**From:** [frances.ceraolo](#)  
**To:** [Chace Pedersen](#)  
**Subject:** ACU-23-00003-Atlas  
**Date:** Wednesday, August 16, 2023 6:23:36 PM  
**Attachments:** [Aerial View Map.pdf](#)  
[Project Narrative.pdf](#)  
[SEPA Checklist.pdf](#)  
[Site Plan and Civil Plans.pdf](#)  
[Correspondence - Deemed Incomplete.pdf](#)

**ACU-23-00003 Atlas Tower**

RE: Zoning Narrative for Telecommunications Facility  
Site Name: Blazing Sky

SHEET TITLE:
SITE PLAN

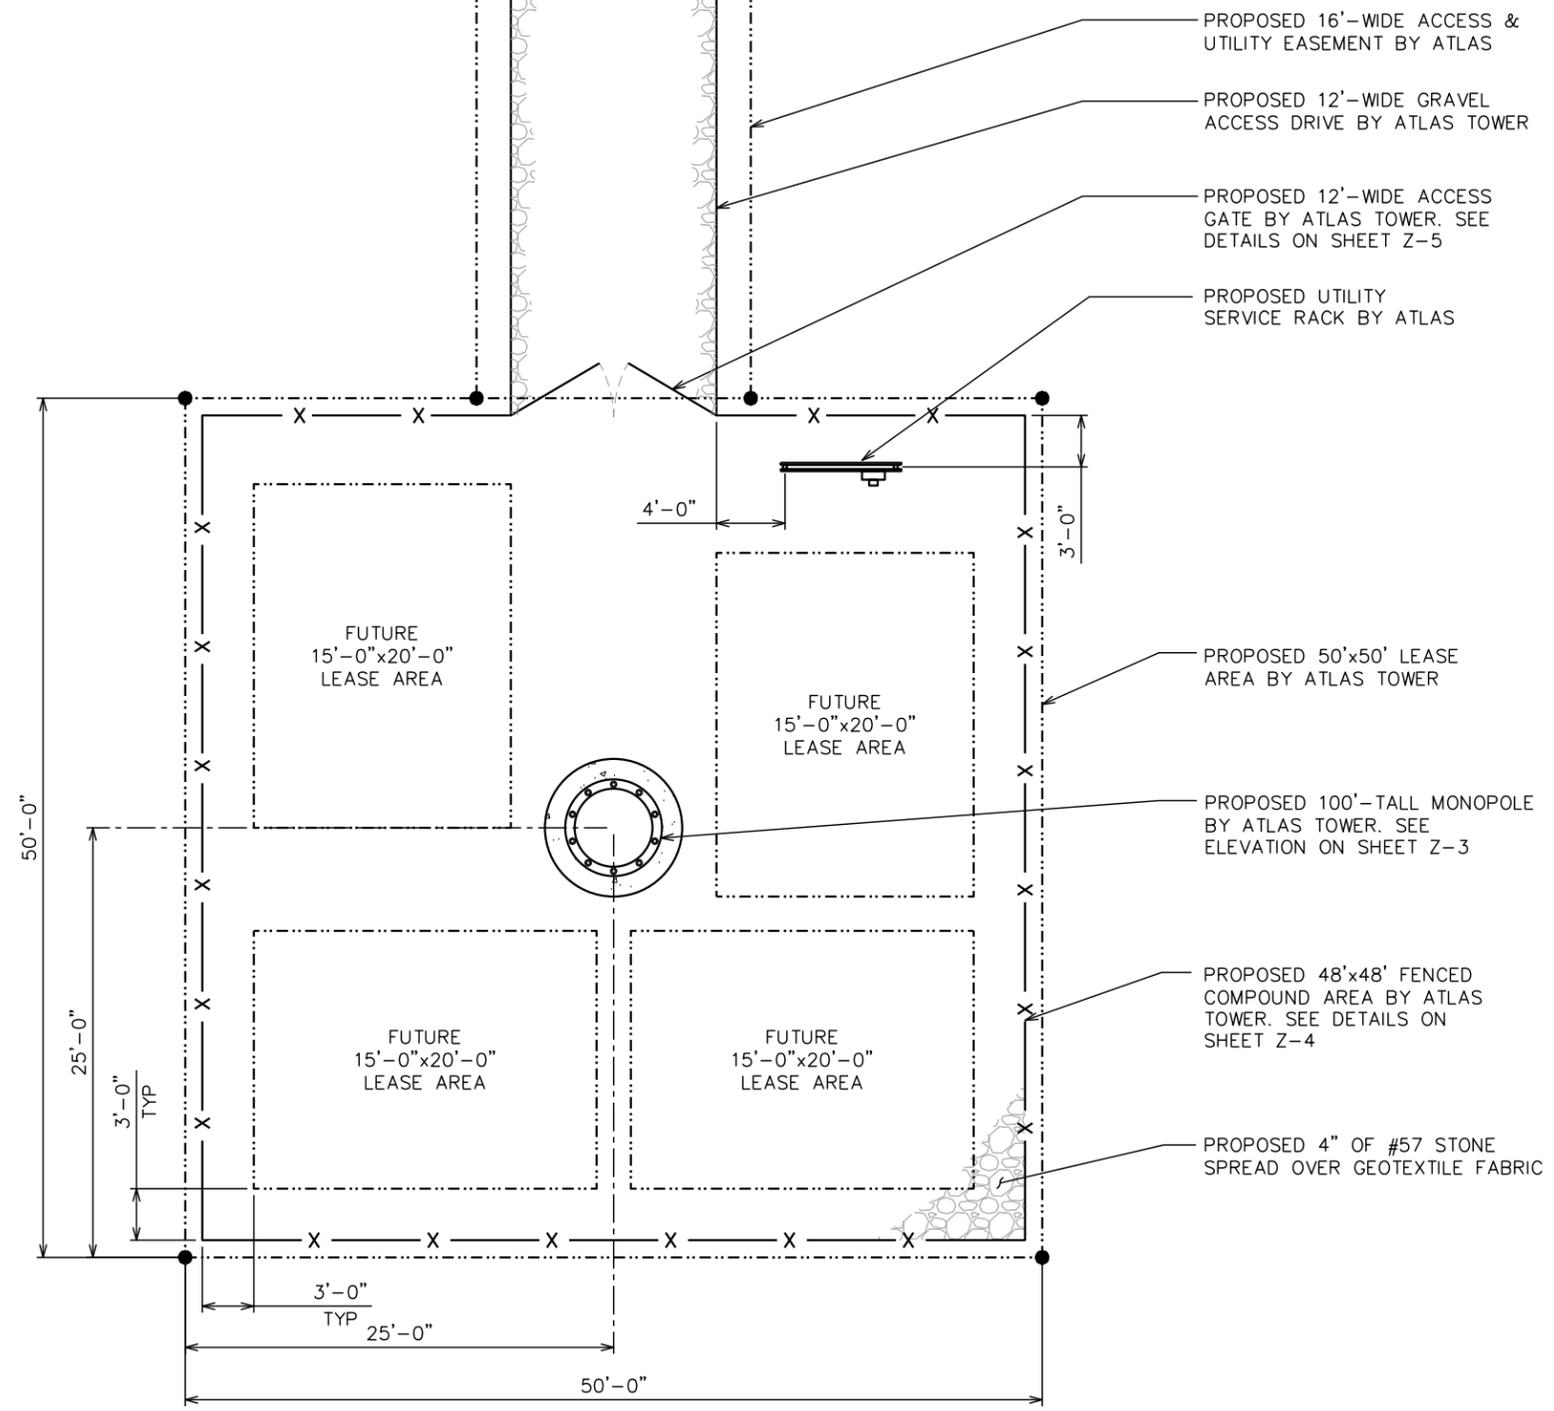
Furthermore no consideration has been given to alternative sites. Victor Strand owns the 20 acre parcel contiguous which includes the 4 acre proposed site. There is adequate space to relocate the proposed tower in the SW or SE corners or even the NW corner of the 20 acre parcel. This would greatly mitigate the problem of distance and sights from nearby residences since the only buildings near the SW and SE corners are barns.

Additionally, there is an existing driveway which would accommodate access to the SW or SE corners and would eliminate the need for an additional driveway on Manashtash Road.
